# ANTLER RANGE FILING NO. 1

ANTLER RANGE FILING NO. 1  
 PLAT

# V2 - Final Plat Drawings.pdf Markup Summary

ANTLER RANGE FILING NO. 1

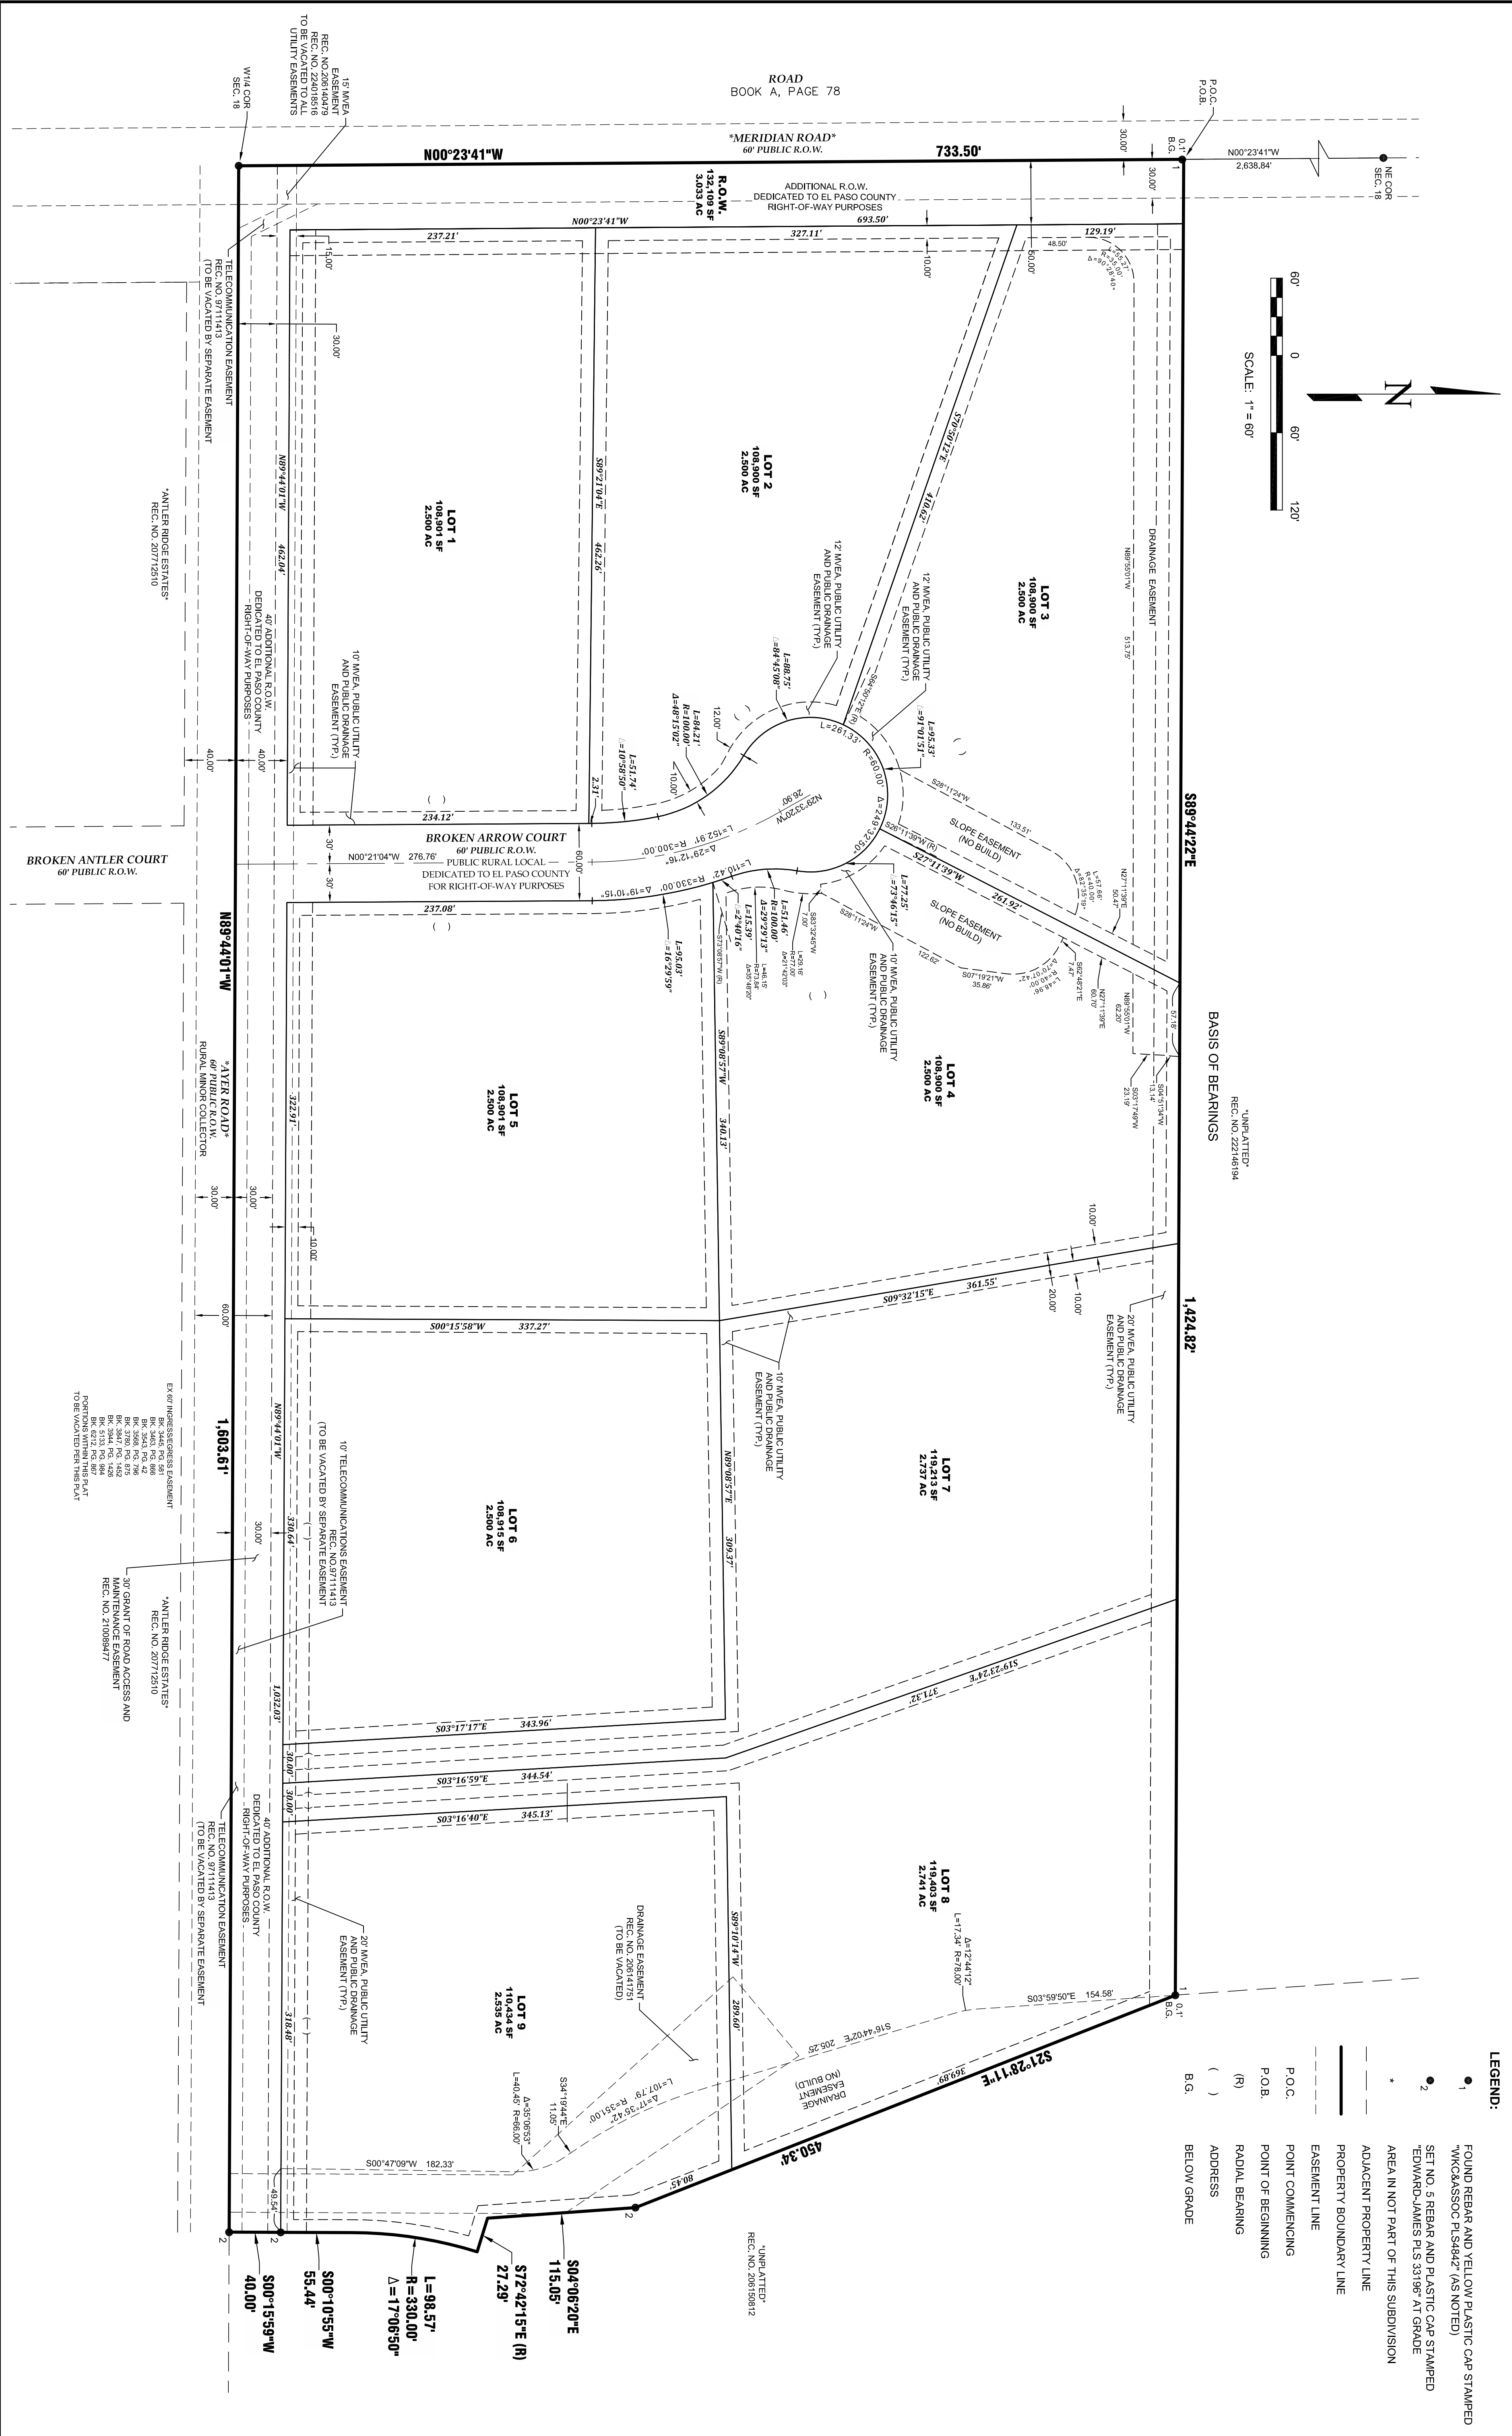
Please delete word.  
 Repeat comment

? update?

Ayer Road access limited to lots \_\_\_ only...

Lot only- there are no tracts...

Add note regarding underdrain requirements as mentioned in comments from the Upper Black Squirrel Creek GWMD.

Please note how that water is to be provided for THIS filing, without a cistern. Cistern to be located on X in Filing No. 2 and maintained by HOA.

Add

A PORTION OF THE NORTHWEST QUARTER OF SECTION 18, TOWNSHIP 12 SOUTH RANGE 64 WEST OF THE 6TH P.M., COUNTY OF EL PASO, STATE OF COLORADO.

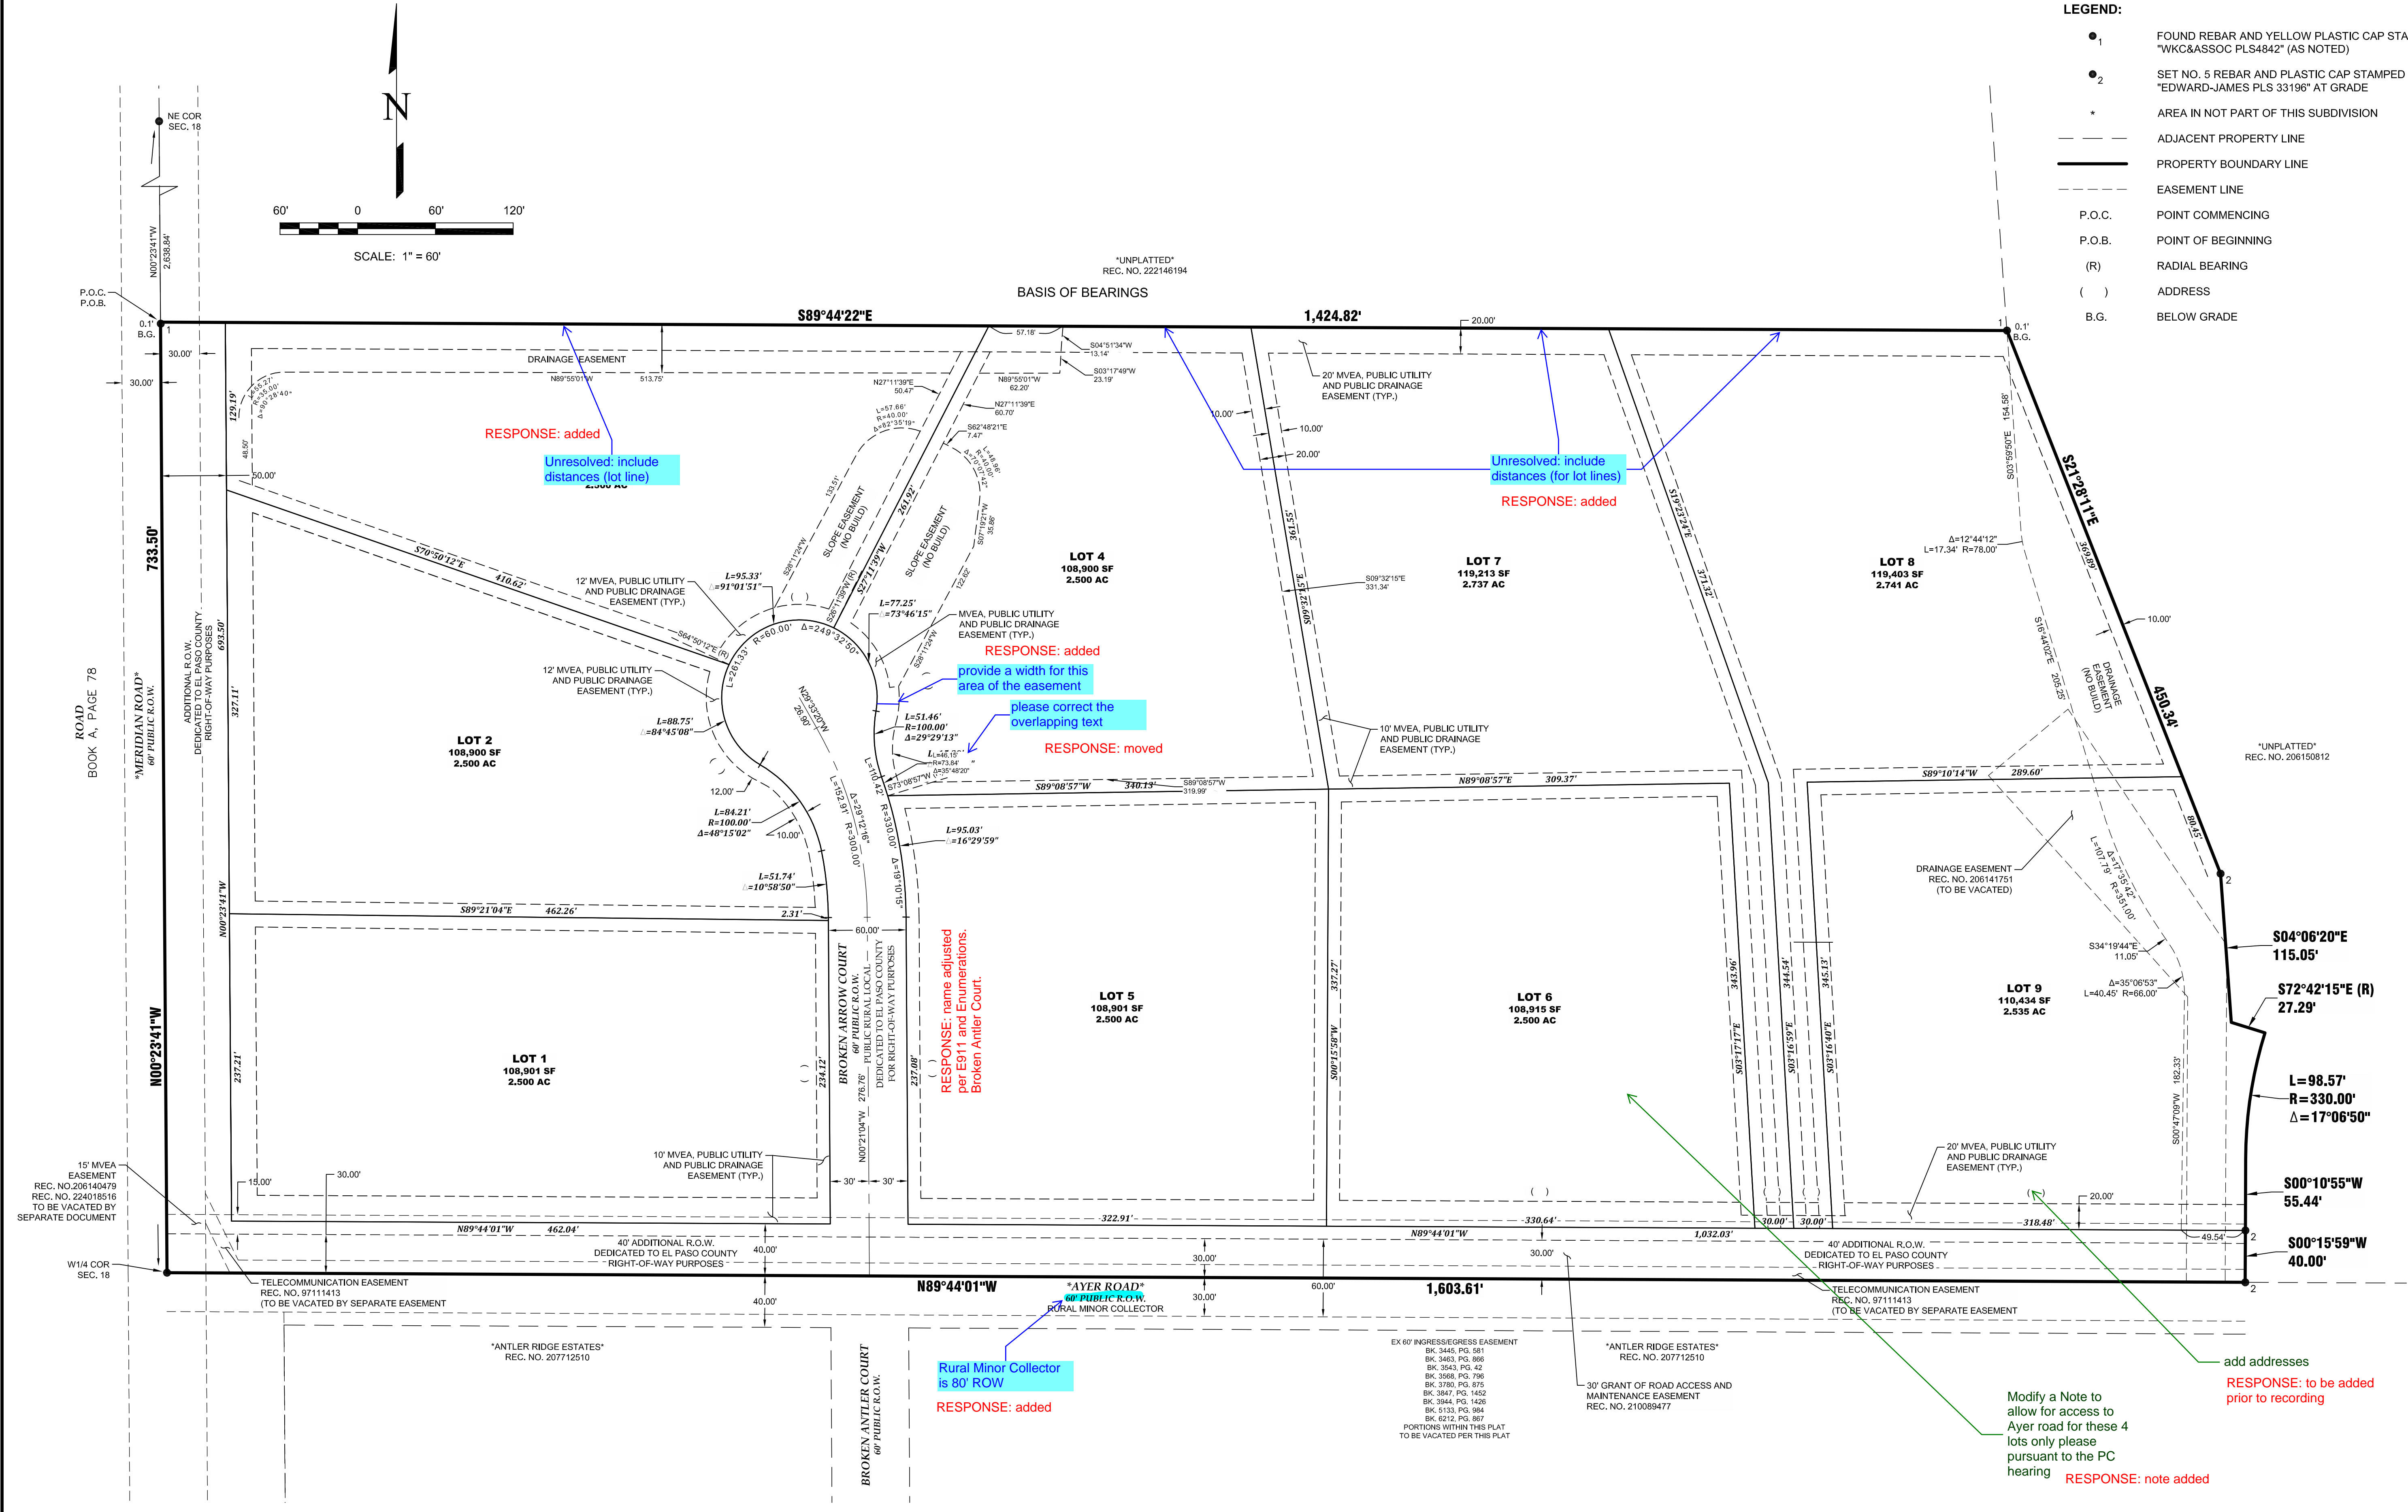
Unresolved: include distances (for lot lines)

Unresolved: include distances (lot line)

Rural Minor Collector is 80' ROW

Rural Minor Collector is 80' ROW

please correct the overlapping text

provide a width for this area of the easement

Modify a Note to allow for access to Ayer road for these 4 lots only please pursuant to the PC hearing

add addresses
